SYDNEY METRO PITT STREET SOUTH OVER STATION DEVELOPMENT

Response to Submissions (SSD
10376 & SSD 8876-2)

4.1 level 06 - plan

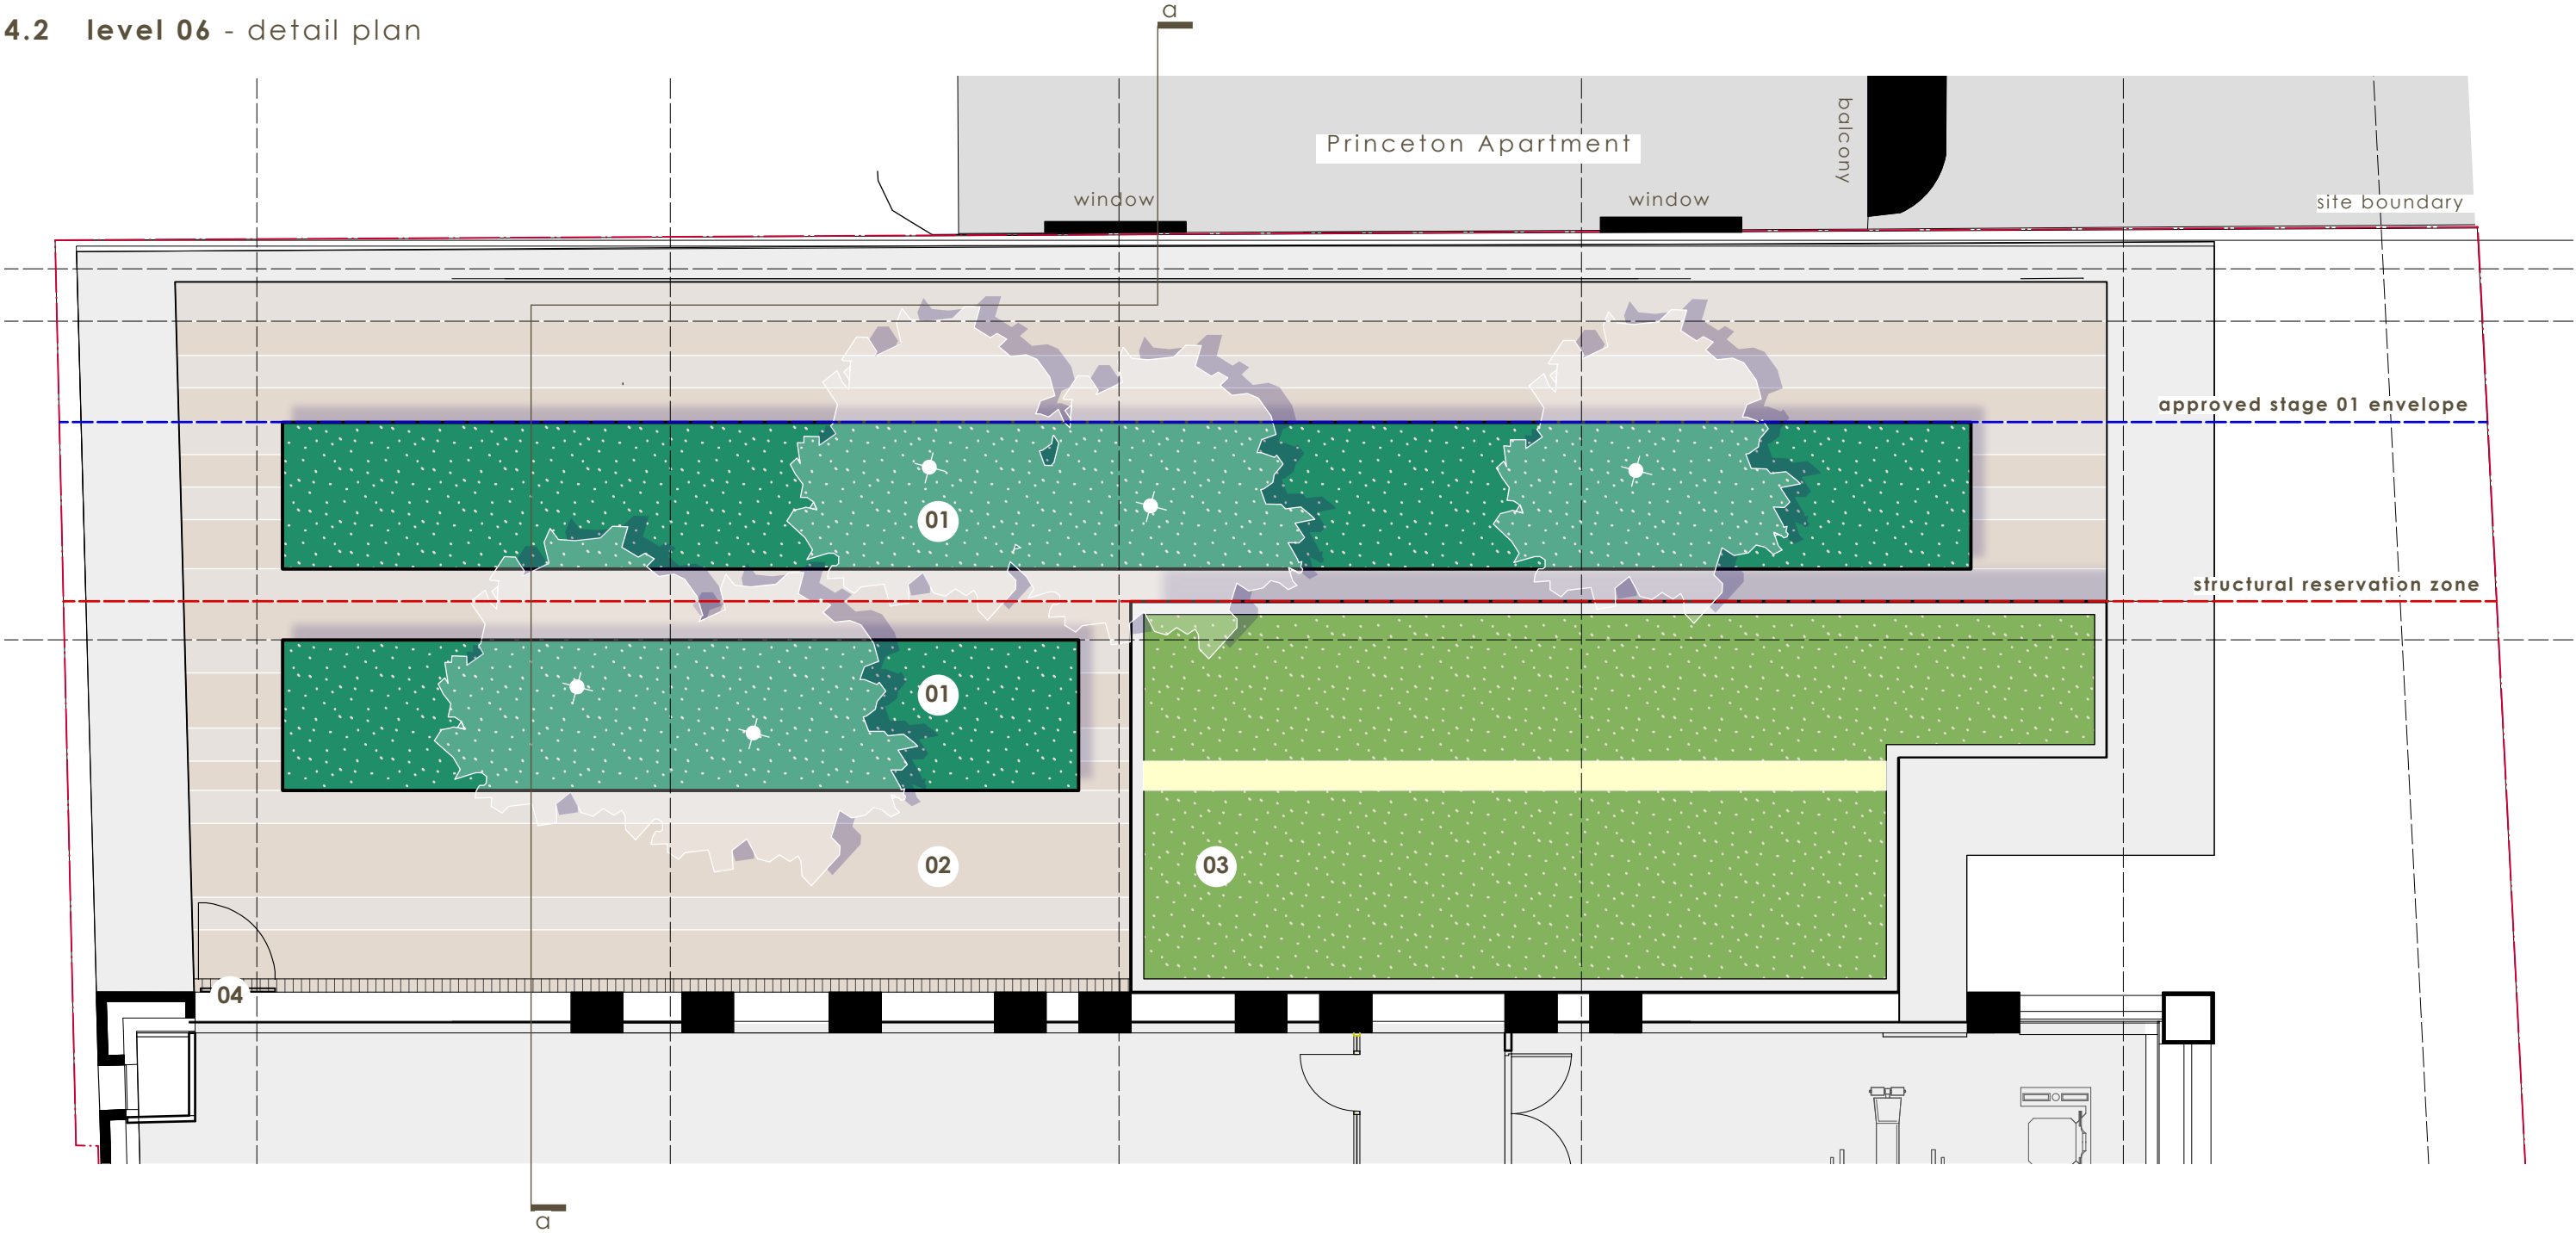
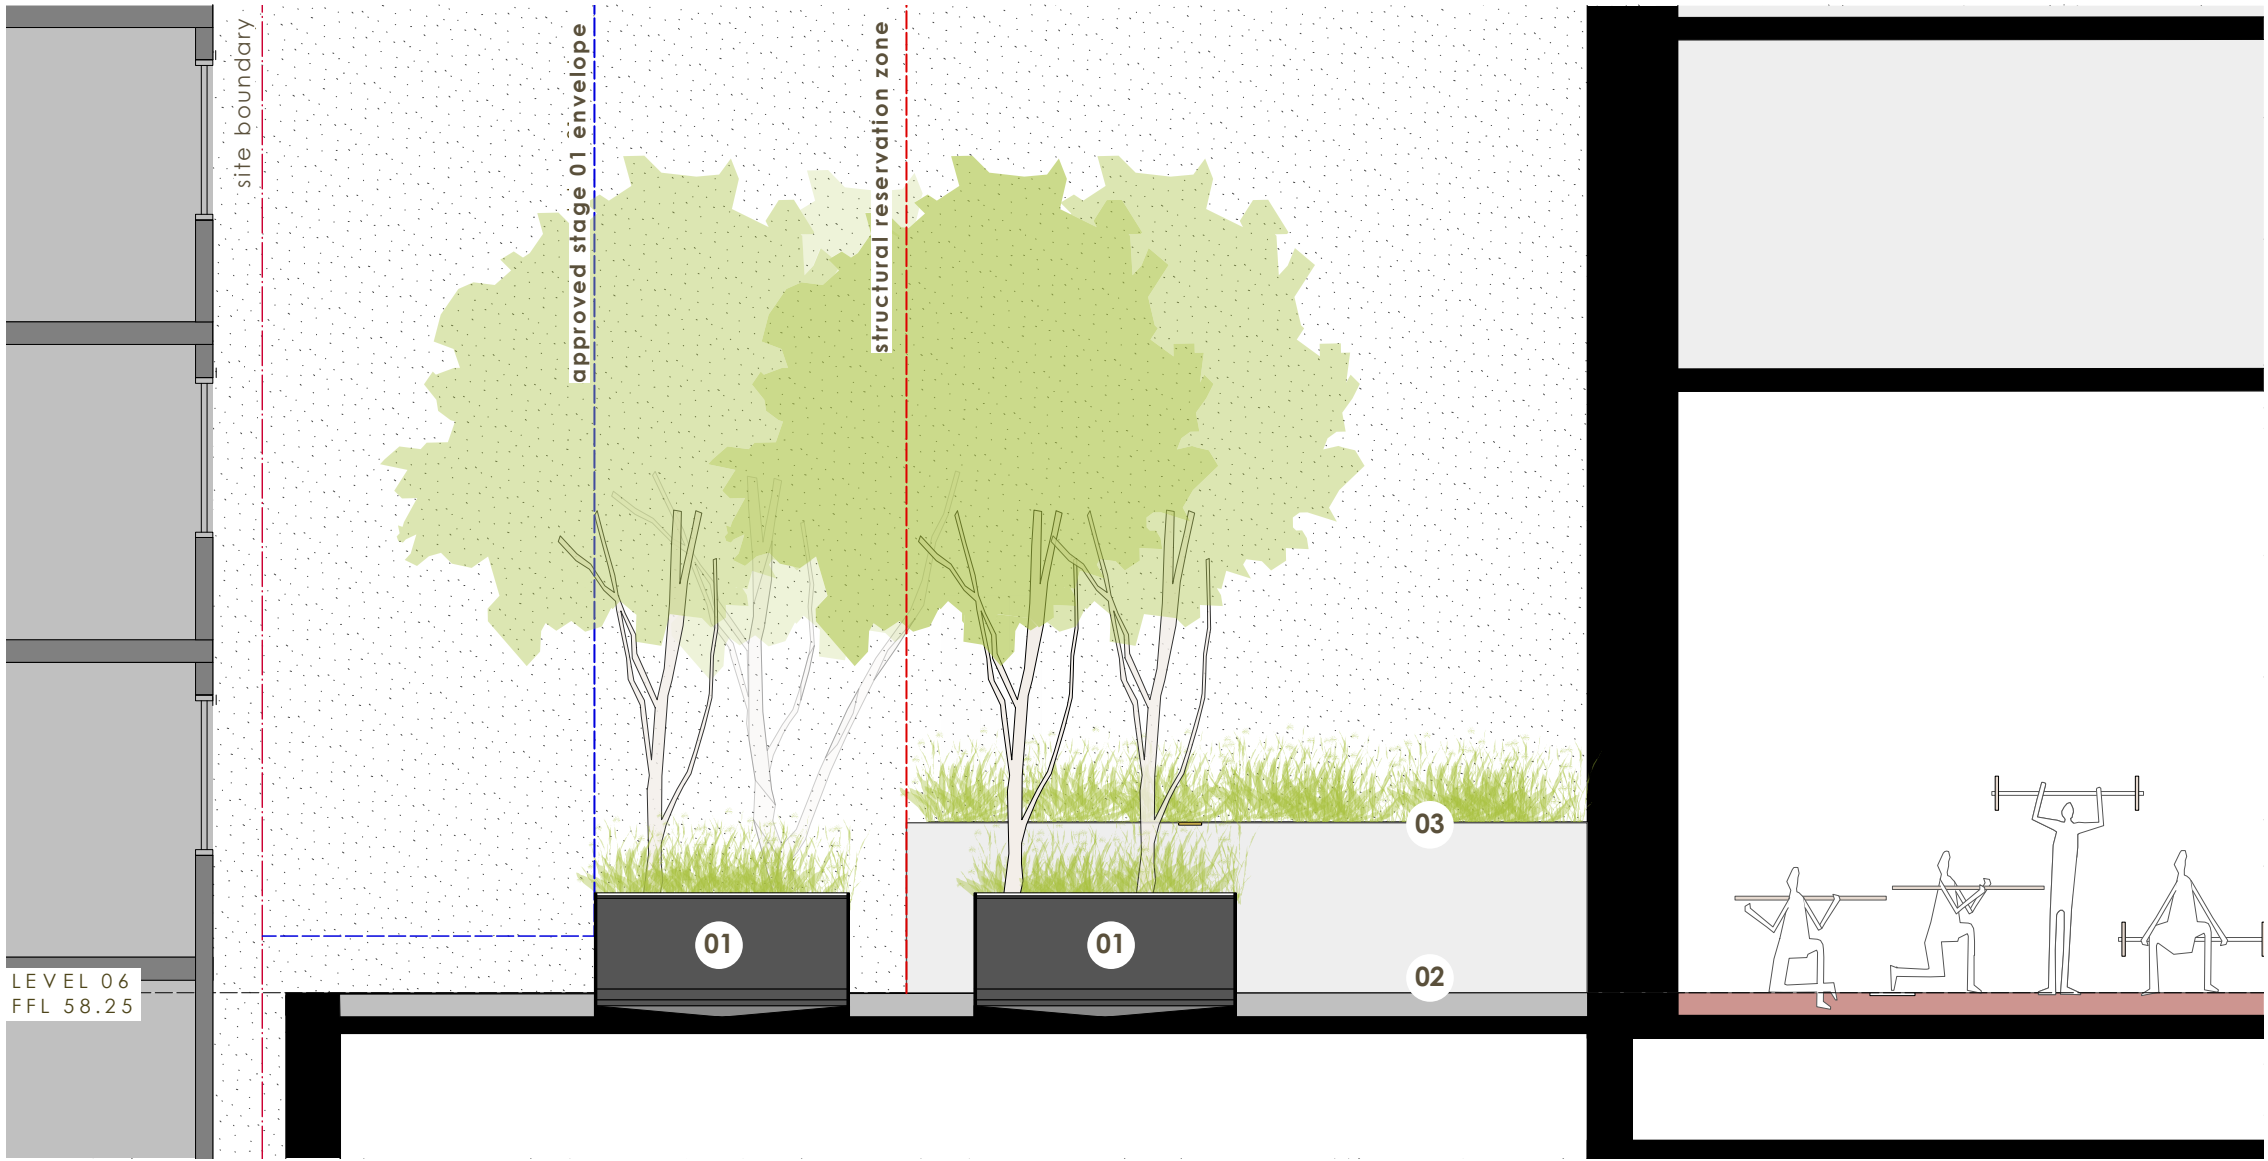
In response to concerns about privacy impacts over Princeton Apartments arising from the Level 06 communal open space this area has been amended to a in-accessible landscaped space. While this area did contribute to valuable communal open space to the development it is acknowledged that the amenity of the space was compromised by low levels of solar access and proximity to habitable windows in the Princeton Apartments' northern facade.

To address submissions raised by the Princeton Apartment residents, the Level 06 courtyard has been re-purposed and redesigned as an in-accessible landscaped space. The space will provide a green breathing space between the Princeton Apartments and the OSD tower providing visual relief within the city and a pleasant outlook for residents both of the proposed development and of Princeton Apartments.

Perimeter balustrade originally proposed along the southern side of the level 6 courtyard has been removed, further opening up the sense of separation and space when viewed from the Princeton Apartment northern windows.

Planting will be located in raised elongated planter beds with light planting on top of the relocated plant room to the west of the courtyard. Plant species selection includes shade-tolerant perennials as a ground cover for the planter beds and above the plant room, as well as a copse of Water Gum providing visual screening between the two buildings. The plant room, at 1.5m high, will create a visual barrier between the internal wellbeing space and the Princeton Apartments northern windows.

The planter beds maximise the extent of landscaping within this space whilst also providing clear paths for maintenance access as required. It is noted all built form has been removed from the structural reservation zone identified within concept approval.

PROPOSED SOUTH EAST APARTMENT

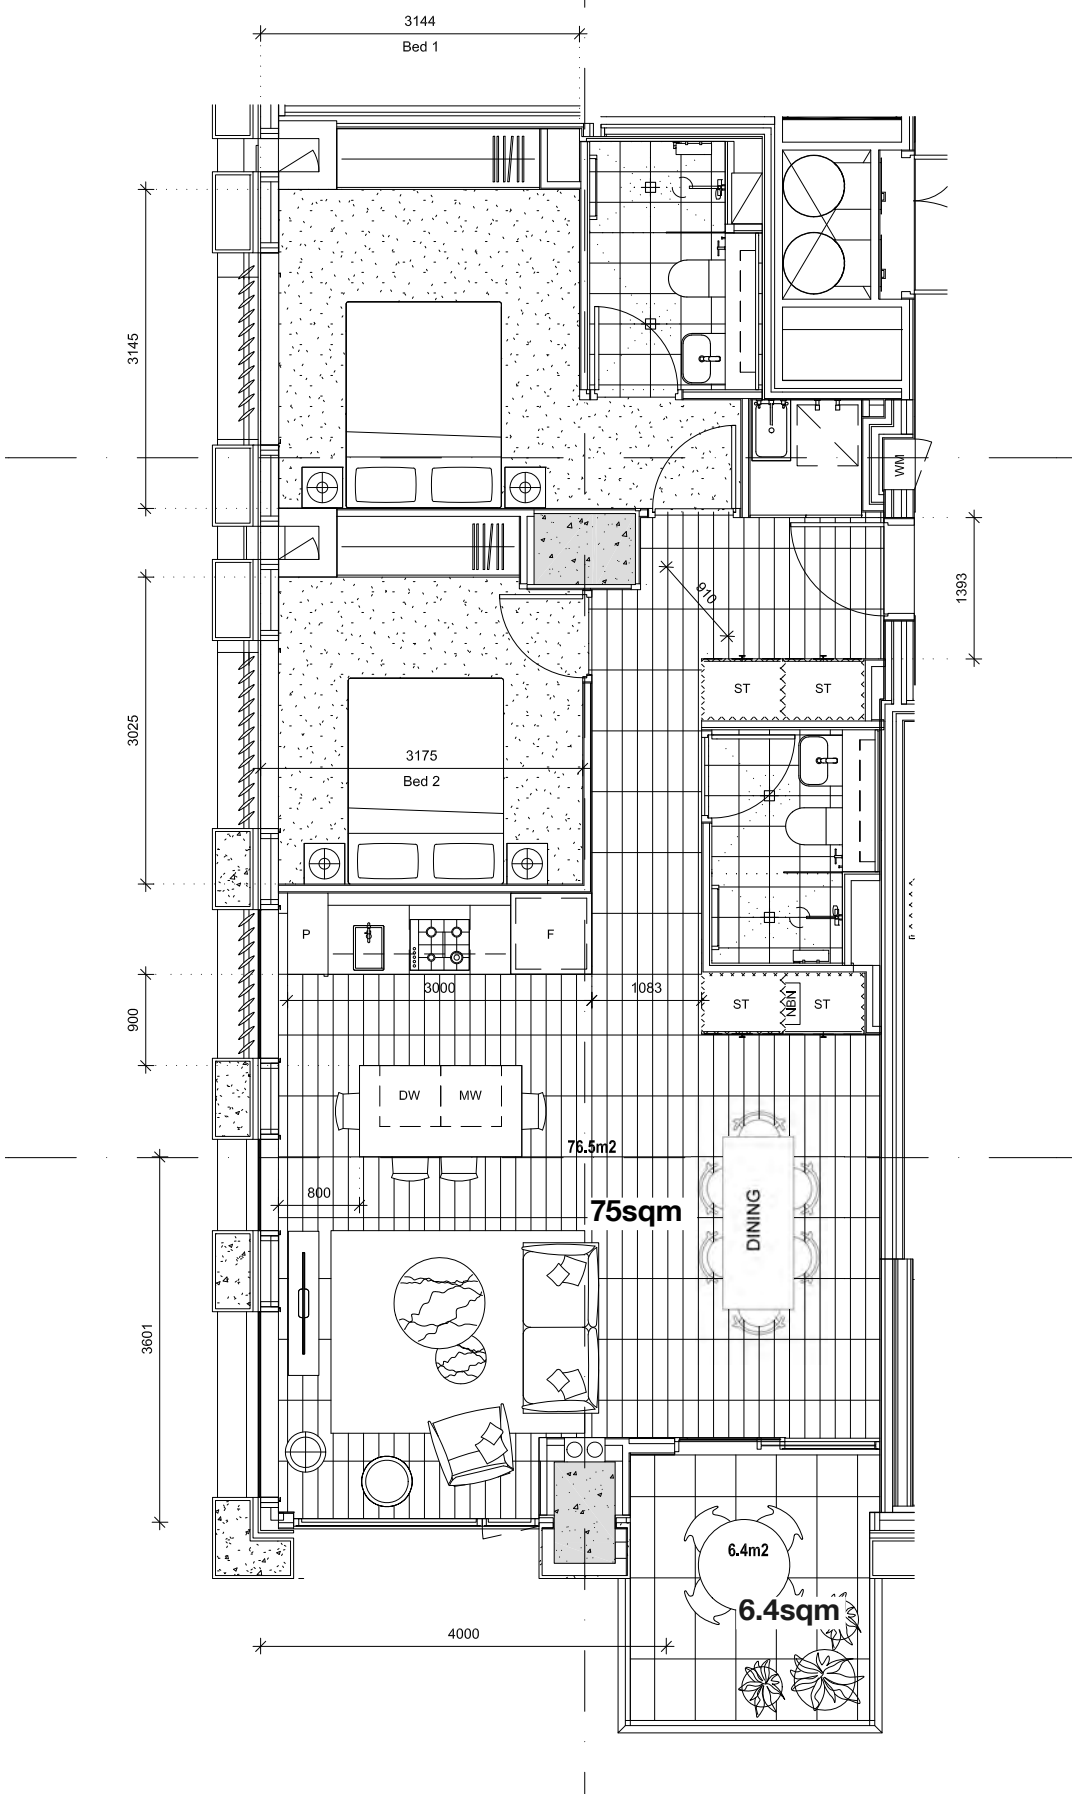
- The Panel supports the studies undertaken to reduce impact on Princeton Apartments from the South East corner apartment balcony but doesn't support a reduction in the proposed apartment size. The Panel would support reduction in balcony size but not size of apartment.

- **Amendments to the layout of apartments on the south eastern corner of the building:** to reduce potential overlooking into Princeton Apartments and to accommodate a balcony relocation to its northern side. Whilst the reduced balcony does not meet the minimum ADG area, this is a preferred outcome whereby the internal apartment area meets the ADG provisions, whilst the balcony relocation provides for increased privacy to and views from Princeton Apartments.
